**Re: Gibson Gas Station**  
**Northeast corner of 98th St and Gibson Blvd.**  
**Traffic Impact Study-draft, HT#M09D034**  
**Report dated October 2022**  
Engineer's Stamp -----  
Via email jkruse@lee-eng.com

The subject Draft Site Traffic Analysis received on October 25, 2022, has been reviewed by the City of Albuquerque Planning Development Transportation Section. The City has the following comments:

RIGHT TURN DECELERATION LANE
SCALE: 1" = 10'

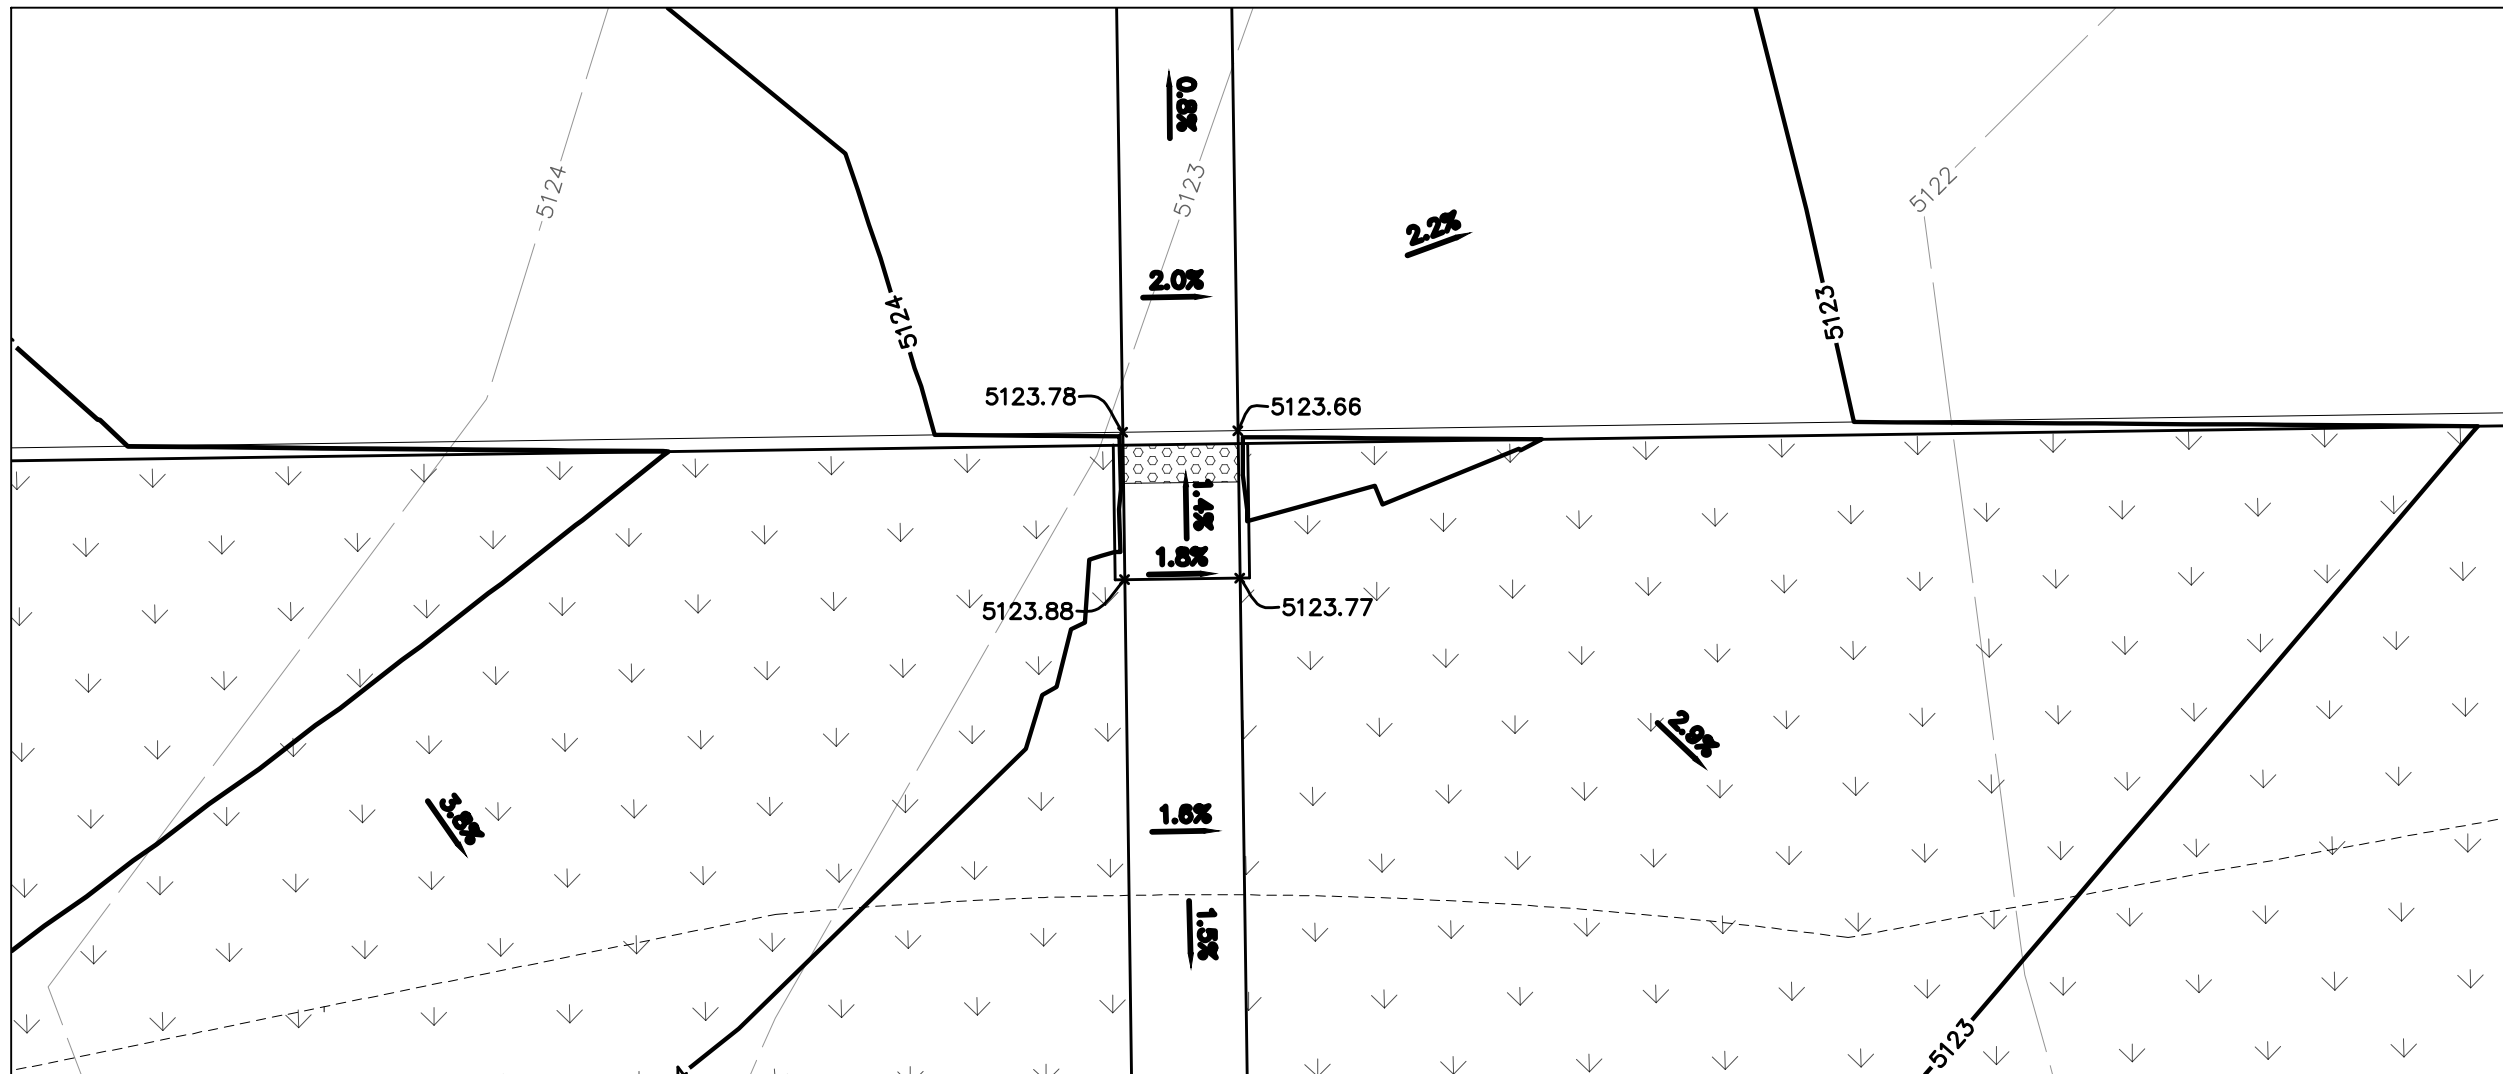
- Relocate Driveway A to the north limits of the development.
  - Add a right-turn lane, the length may be less than the DPM requirement. The City may accept a reduced length of the turn lane. Provide a short discussion on the effectiveness of the modified turn lane.
